From: Simon Davis
Sent: 05 March 2019 17:49
To: Planning.Responses
Cc: Martyn White
Subject: FW: BR/326/18/PL - The Royal Hotel, The Esplanade, Bognor Regis
Attachments: 169 3.106 Rev 02 Proposed Roof Plan.pdf; 169 3.105 Rev 01 Proposed Fourth Floor.pdf

From: Stephen Brooker [REDACTED]
Sent: 05 March 2019 17:33
To: Simon Davis [REDACTED]
Subject: RE: BR/326/18/PL - The Royal Hotel, The Esplanade, Bognor Regis

CLIENT	Metamorph Management LLP
PROJECT	The Royal Hotel Apartments
DATE	December 2018
DRAWING TITLE	Proposed Roof Plan

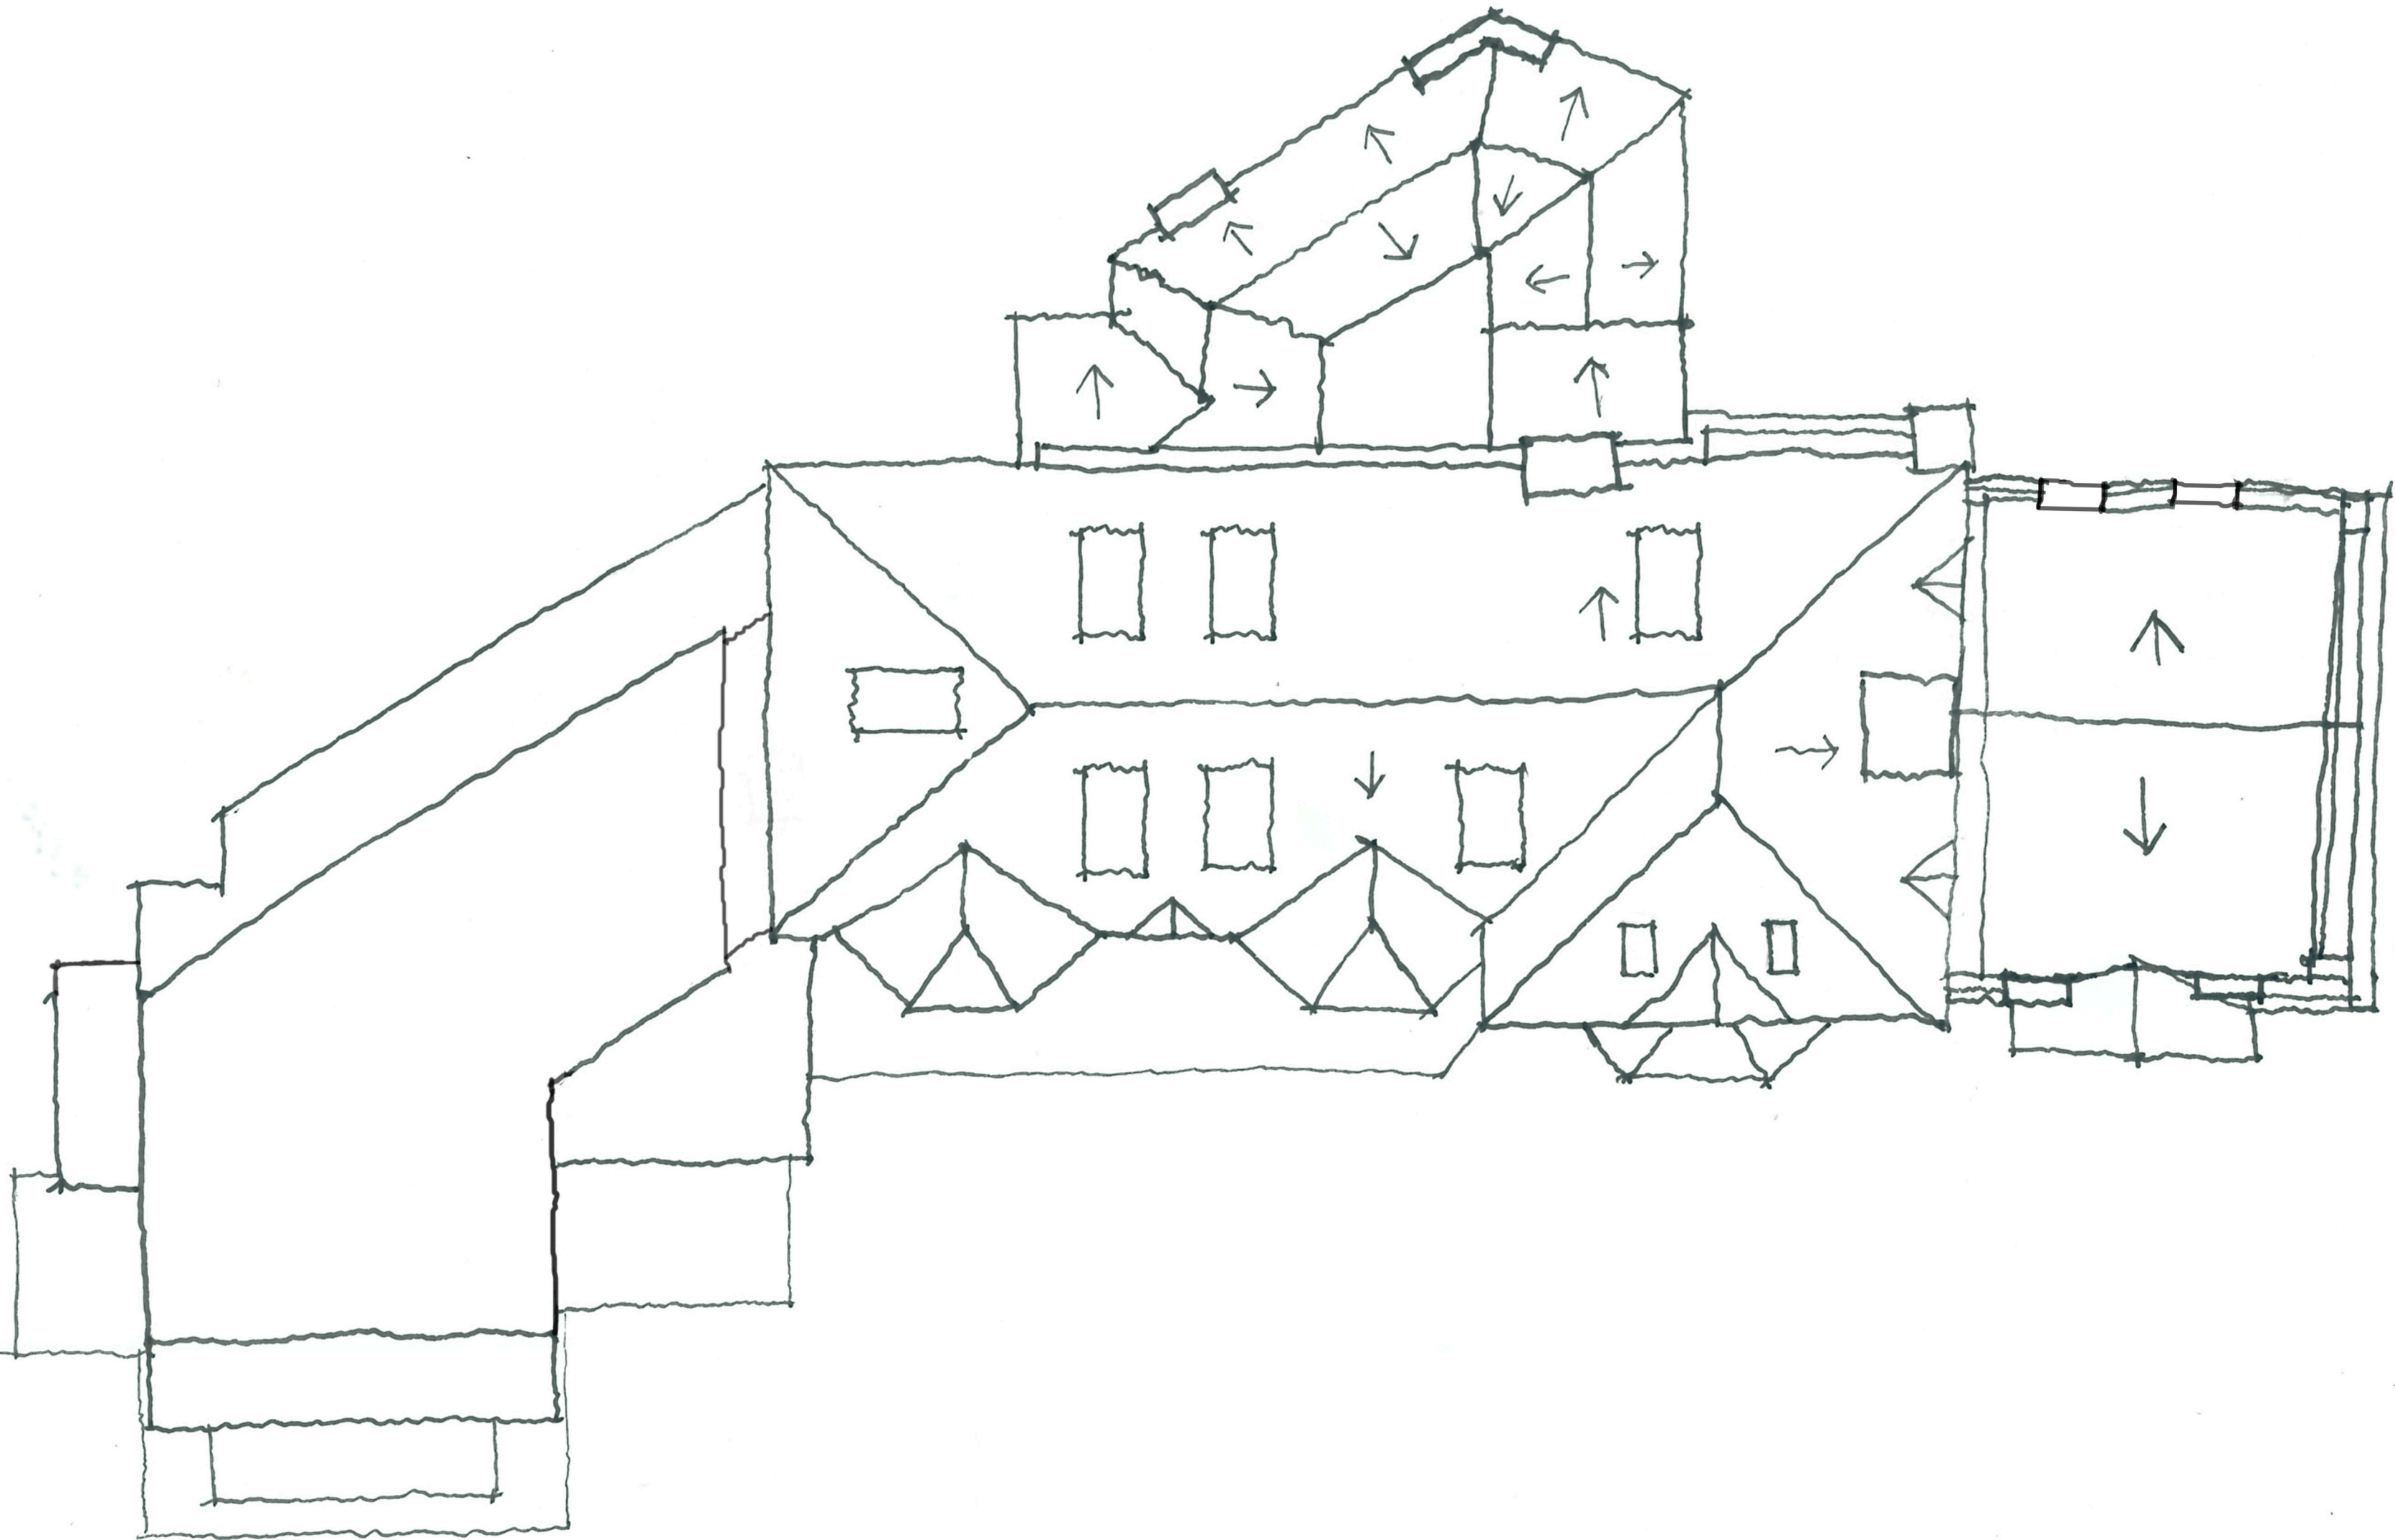
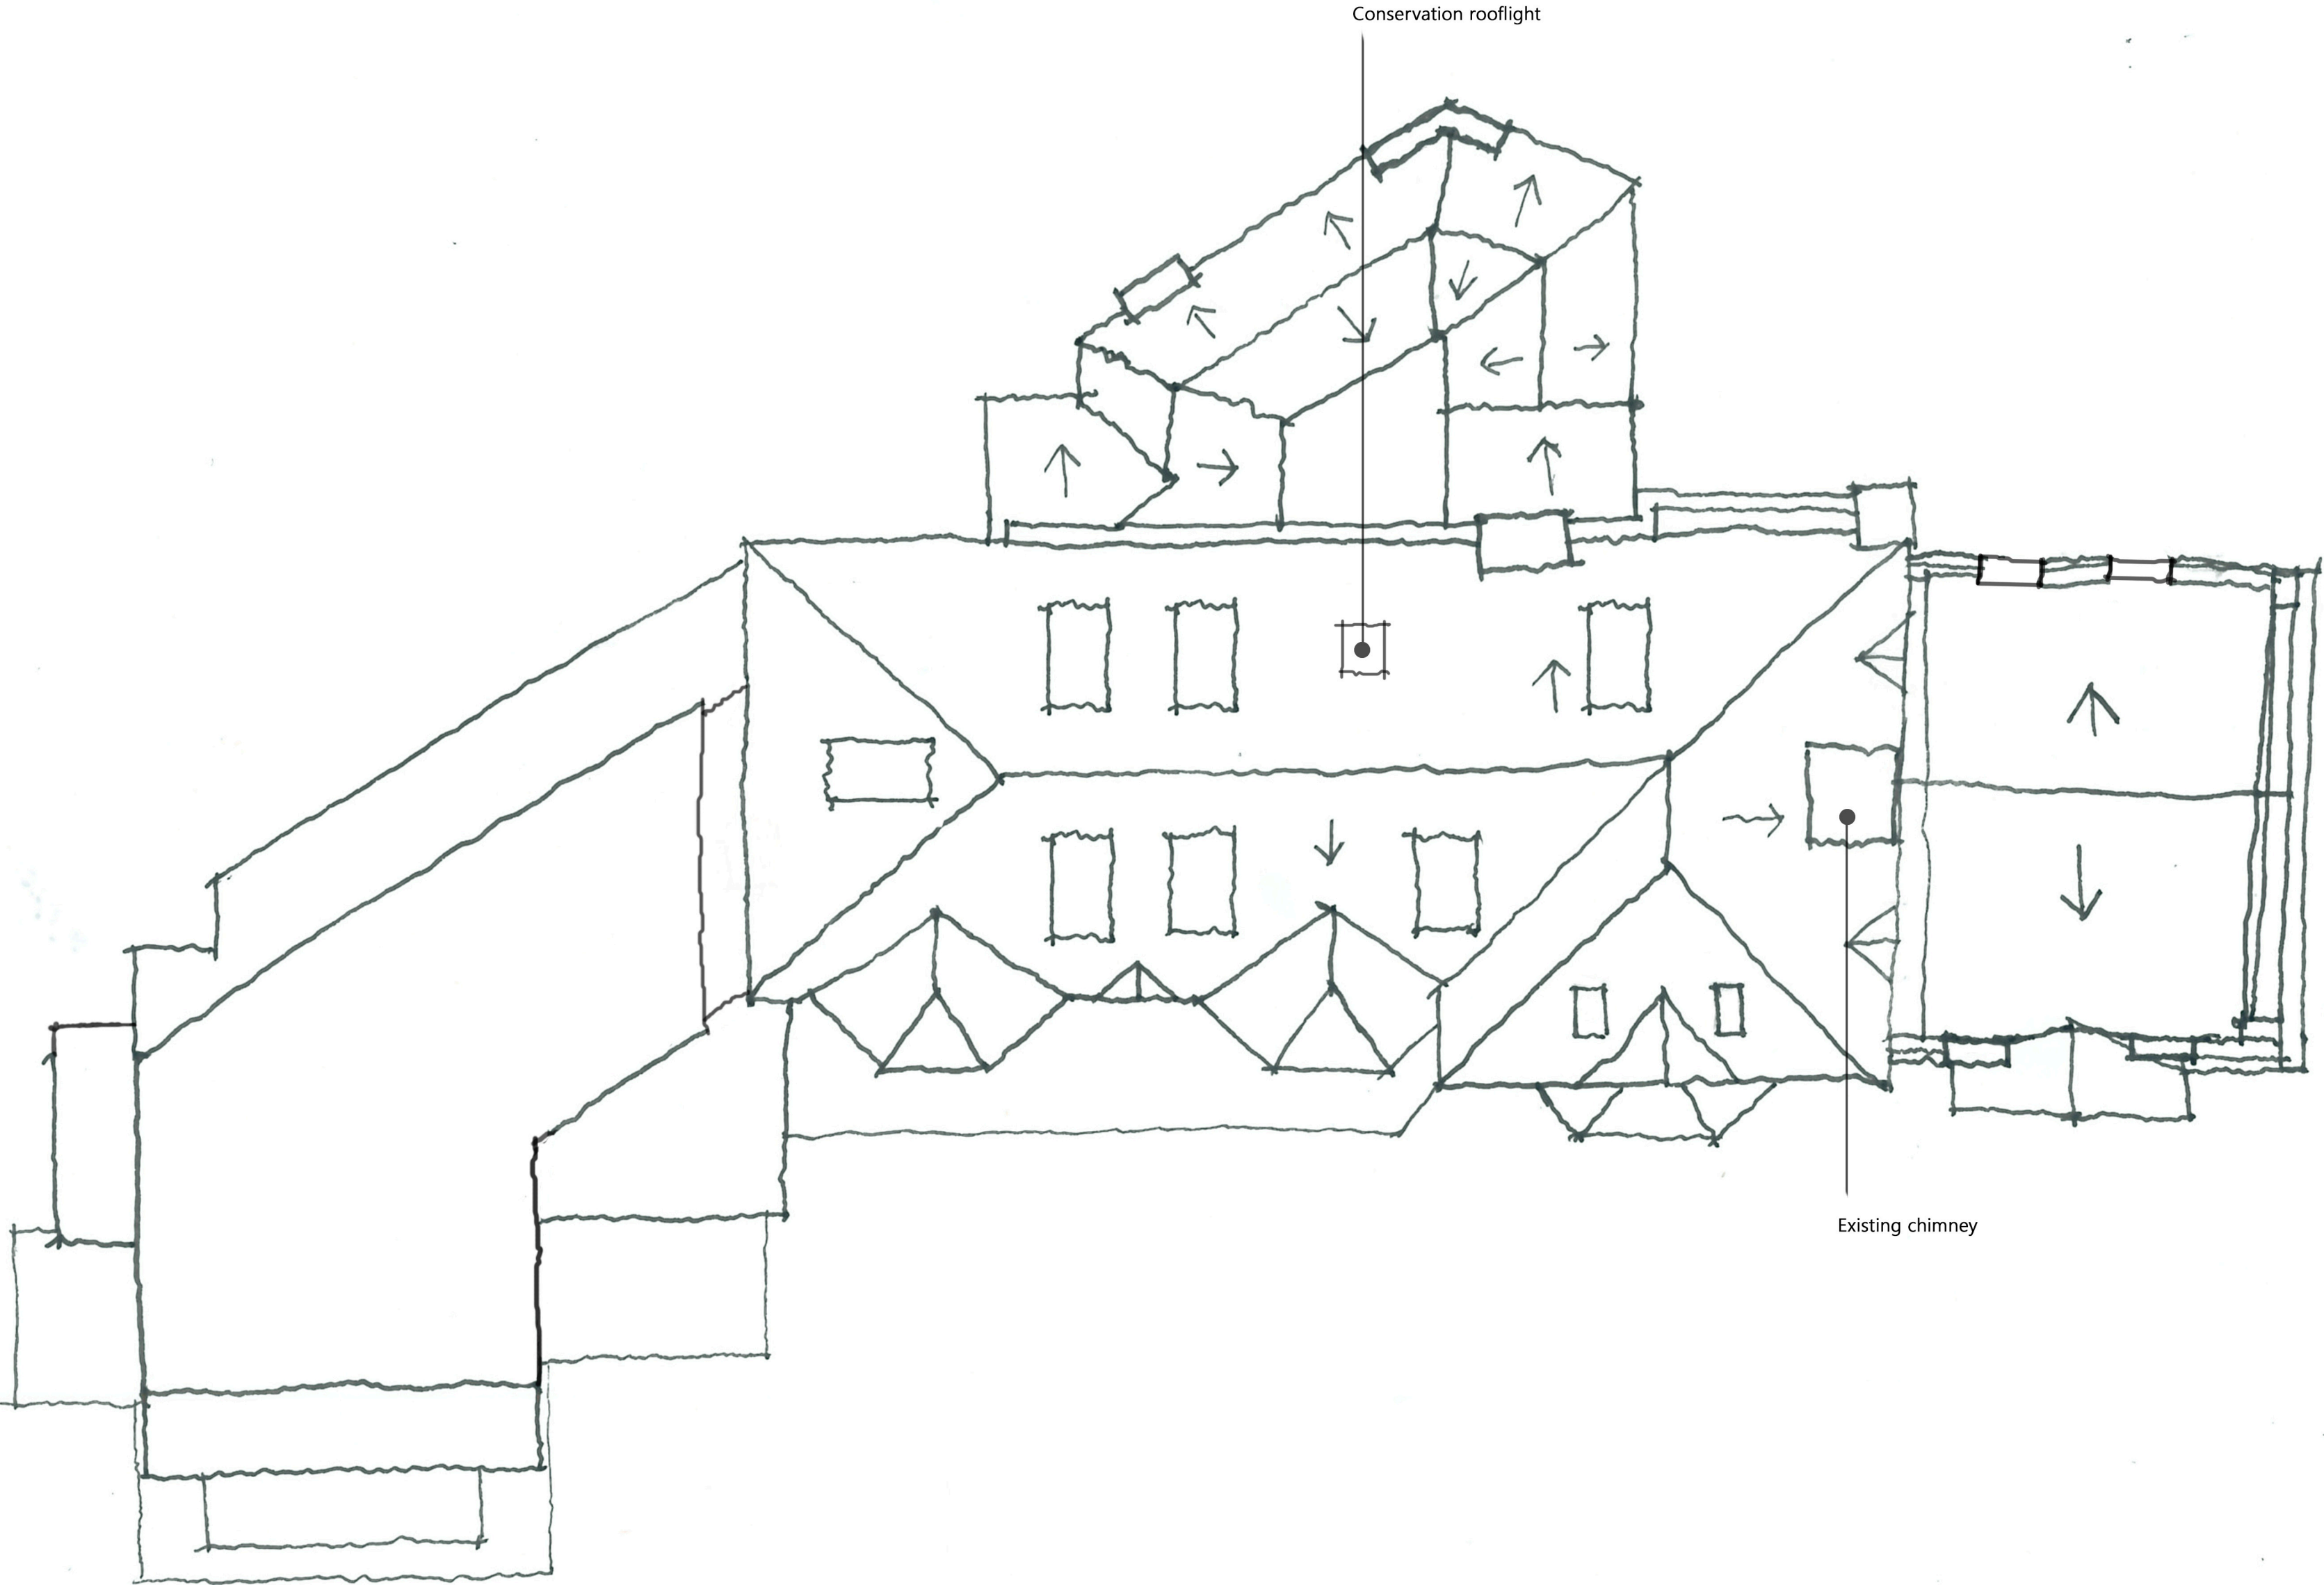
Separately, please see two annotated plans attached. On the roof plan (block plan), it looks like there is a dormer on the eastern flank of the main roof and this is not shown on the N or S elevations. It may be that the missing dormer is actually a velux or the position of the chimney though (as I don't have the fourth floor plan, I haven't been able to check). Also there is a conservation rooflight shown on the N elevation of the main roof but not shown on the roof plan.

One thing he mentioned (and was going to be in his response) was a discrepancy with the plans regarding the dormers on the flank roof planes of the main roof. I think from memory that there are some elevations and possibly the upper floor plan where one or both of these are not shown. I also think he had said that some of the drawings have not made it onto our website. I can't compare to the file at present as Martyn has it but I can't see a third floor plan or an east elevation on the plans we have uploaded. If these are a thing, can you email to me and I'll fix the public viewer. Please also have a look into the dormer issue.

The square shape on the roof plan on the eastern roof slope was not a proposed dormer, it is the chimney (now labelled as such) which means no need to alter the elevations or 4th floor plan to show it. The roof plan has also been altered to show the rooflight shown on the north elevation.
